Recommendation Report for Planning Permission for Works or Extension to a Dwelling

REF NO: AW/236/21/HH

LOCATION: 25 The Fairway
Aldwick
PO21 4HD

PROPOSAL: Erection of single storey rear extension. This application may affect character & appearance of a conservation area.

PROPOSED ELEVATIONS

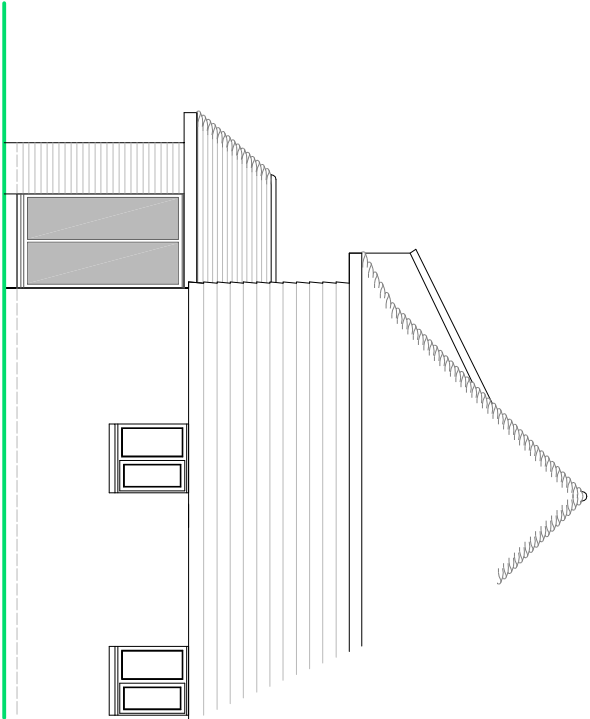
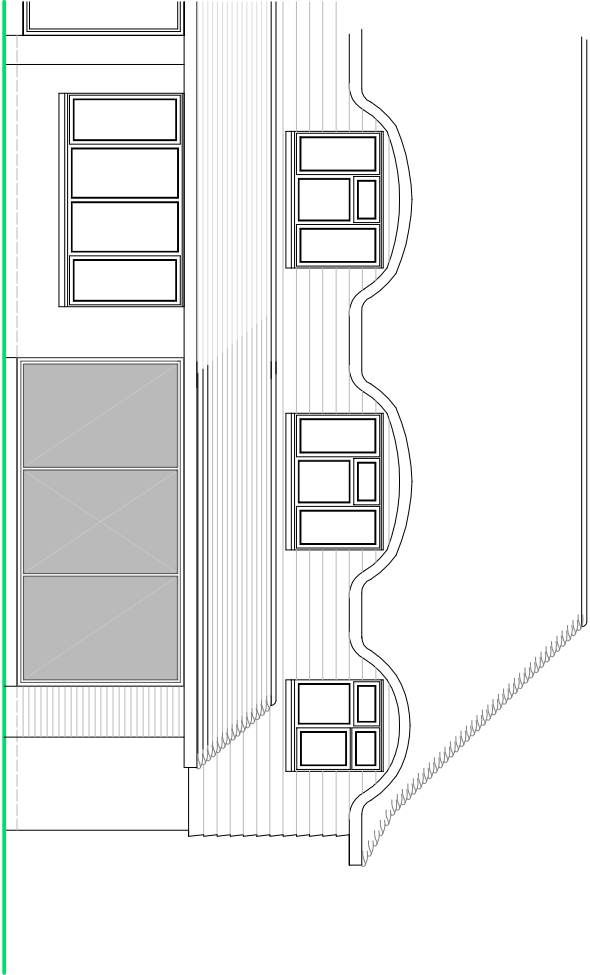
DESCRIPTION OF APPLICATION	The application seeks planning permission for the construction of a single storey rear extension measuring approximately 1.9m in depth and 5m in width with an eaves height of 2.37m and a ridge height of 3.6m. The extension would be constructed from materials which will match in appearance those of the existing dwelling.
RESIDENTIAL DEVELOPMENT N/A DENSITY (NET)

The extension will reflect the scale and appearance of the existing single storey element to the rear of the dwelling. The extension appears in keeping and sympathetic to the character of the dwelling.

By virtue of the extensions location to the rear it will not be visible in the street scene and as such would not give rise to any adverse harm to the established character of spatial pattern of the locality.

The single storey extension is sensitively designed, constructed of appropriate materials and is sympathetic in scale, form and detailing and retains the qualities of the existing building. The extension accords with policy HER DM3 of the Arun Local Plan and the National Planning Policy Framework.

SITE PLAN - 1/500

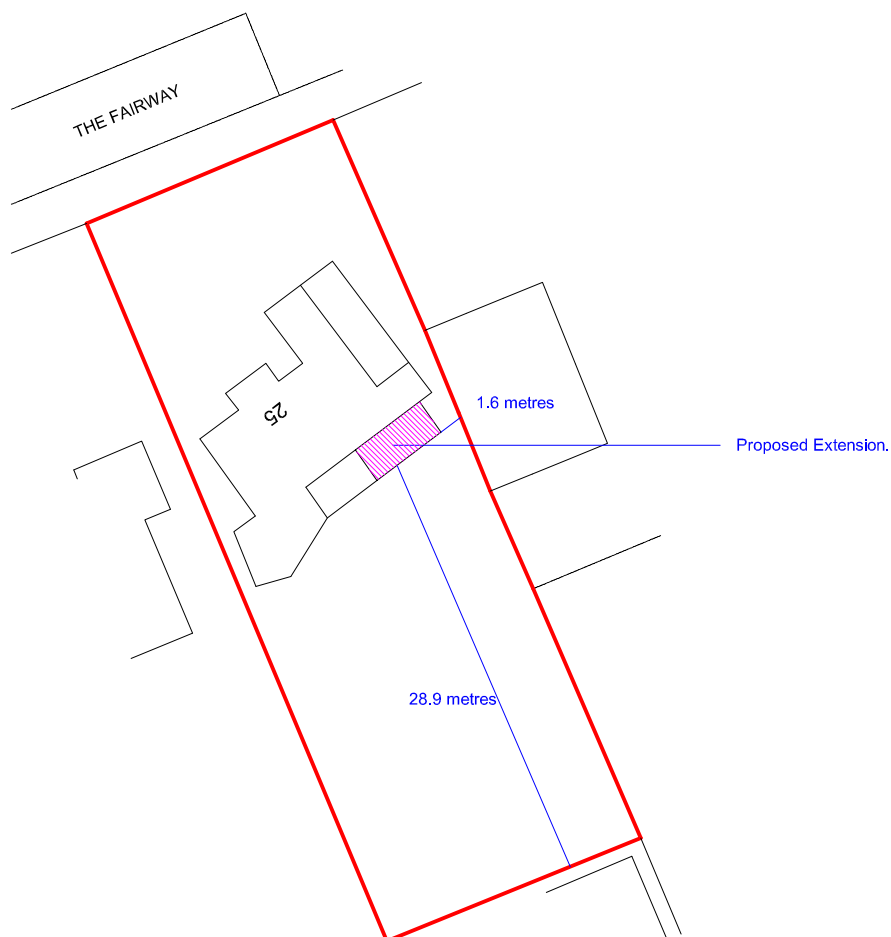
The extension will be located approximately 1.62m from the boundary at its closest point and the neighbouring single storey garage. Despite the proximity of the extension to the boundary it is considered that by virtue of its design and scale that it would not give rise to any unacceptably adverse overbearing or overshadowing impacts on the residential amenity of neighbouring properties.
